**Environment  
Agency Written  
Representation on  
Sizewell C  
Development  
Consent Order**

Our Reference: AE/2021/126206/01

2 June 2021

SCALE BAR:
10m 0m 10m 20m 30m
Scale 1:500

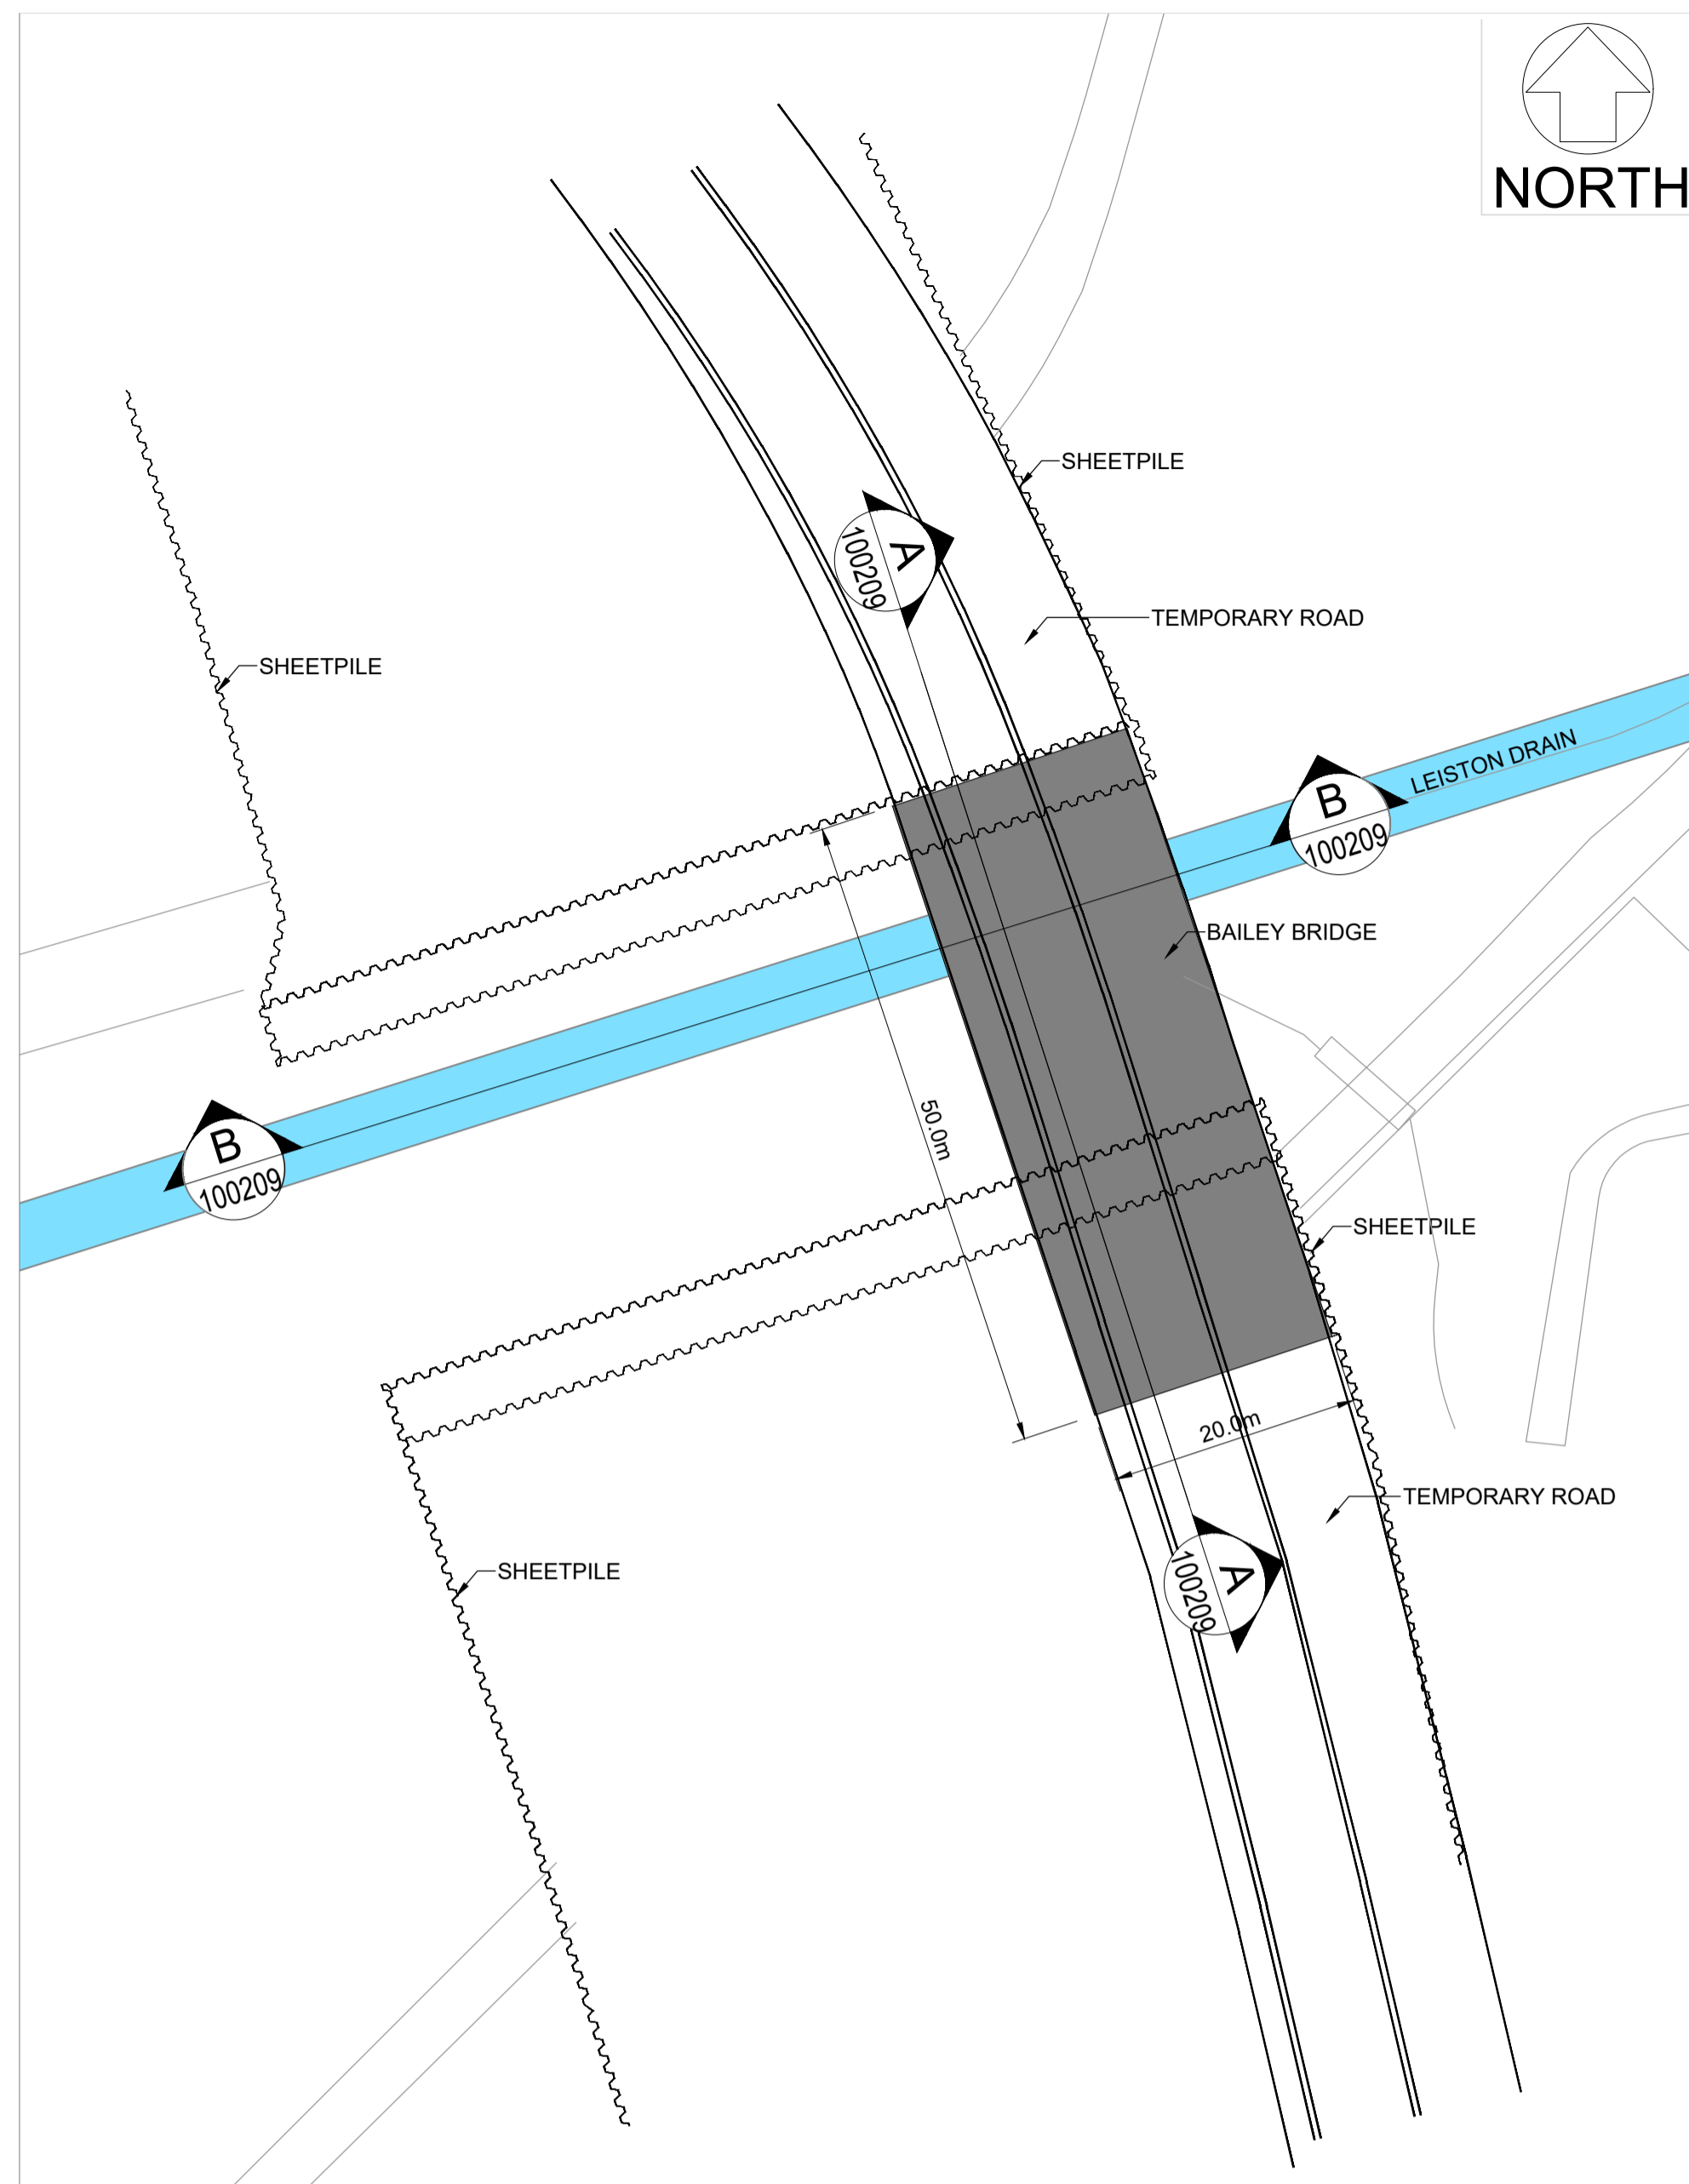
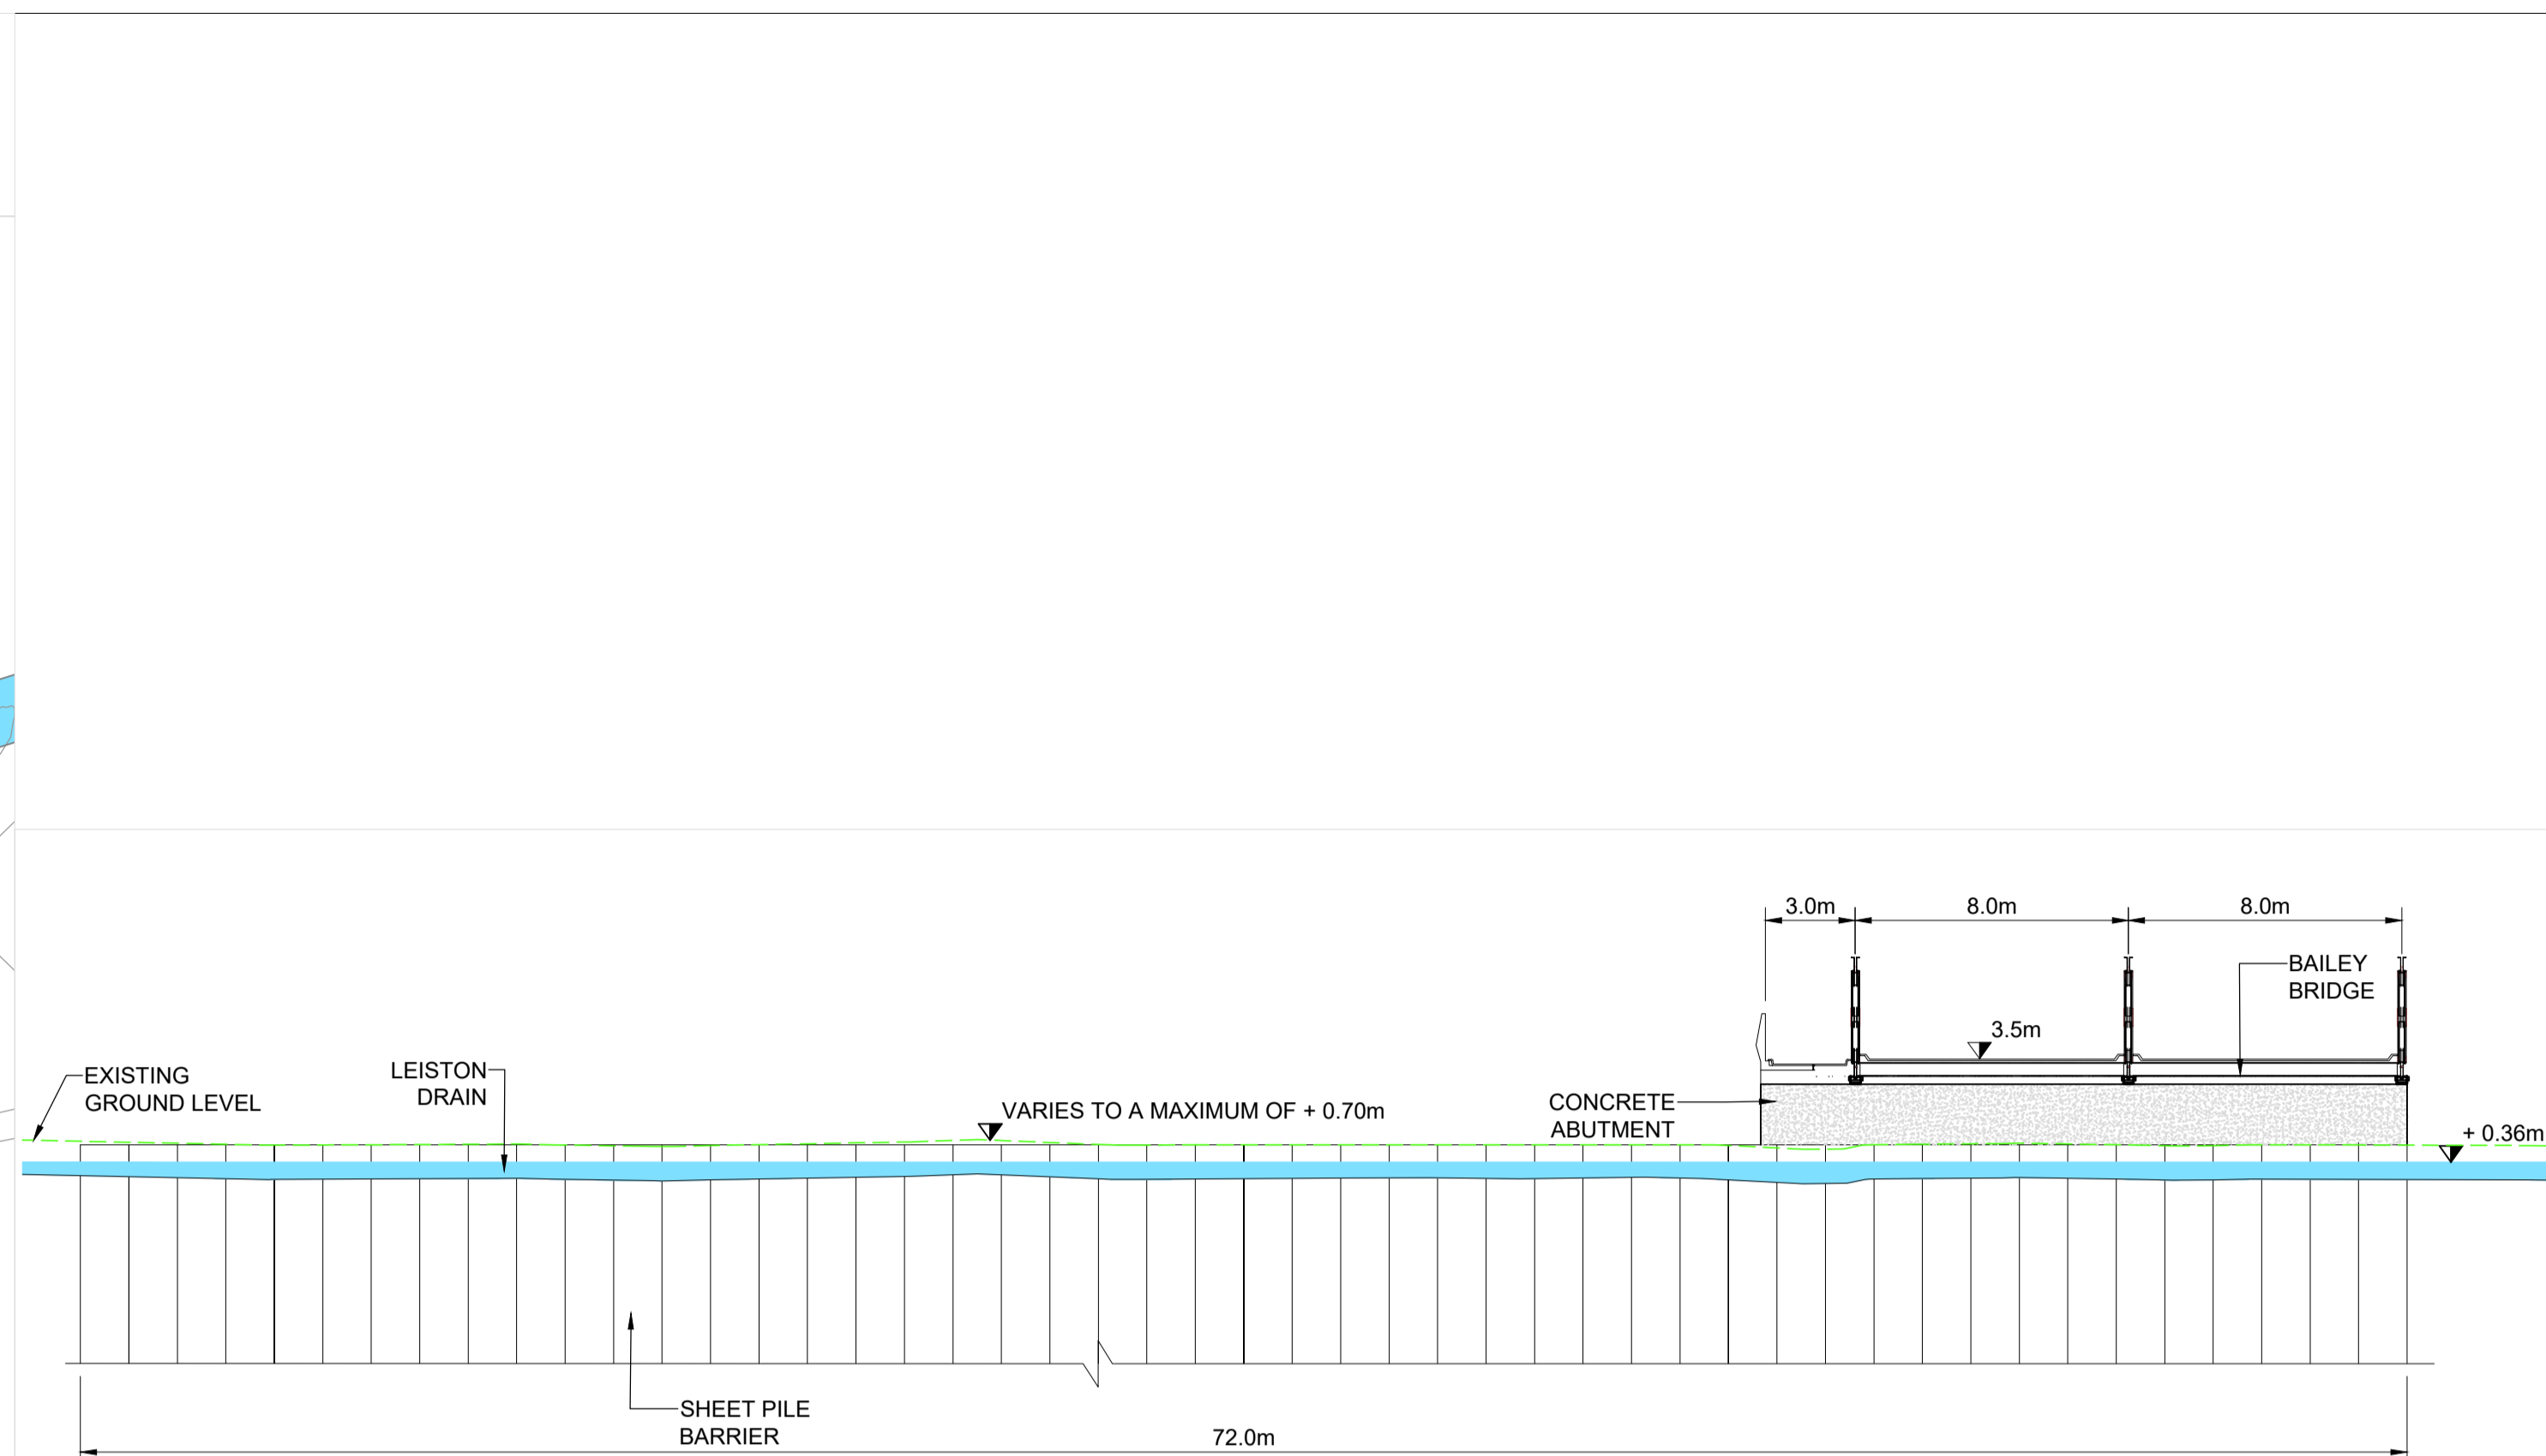
- 7.0 The change to the design of the SSSI crossing is an improvement from the previous culvert design because it will better facilitate the passage of mammals including otters and water voles. However, the proposed design will be impassable by certain invertebrates due to the height of the crossing and the large shaded area under the crossing.

- 7.1 The proposed design of the SSSI crossing would prevent the upstream and downstream migration of numerous invertebrates either side of this significant structure approximately halfway along the river, and its associated SSSI designated habitat. This will lead to fragmentation of sensitive habitats and the isolation of species populations, some of which are not resilient to this kind of impact and will be significantly less resilient to future impacts. Choosing this approach to site access may well lead to a detrimental population decline in this area for several important species. We understand that NNBGenCo (SzC) are carrying out a design review to consider if the design of the structure could be optimised to further reduce impacts. At Deadline 4 we anticipate confirmation of a design 15m wide, with an increased soffit height, which would be an improvement upon the current design.

- 7.5 **Fish:** The changes to the SSSI crossing will likely improve fish passage along the Leiston Beck but a deeply shaded area under the crossing will remain; a threshold of light intensity will determine what species are likely to pass under the crossing. This could lead to large scale fish mortality when fish are prevented from moving along a watercourse during events when water quality is reduced to a critical level, such as algal blooms, or pollution events. NNBGenCo (SzC) Ltd has indicated that there will be further optimisation made to the design of the SSSI crossing, which will be necessary to resolve these impacts.
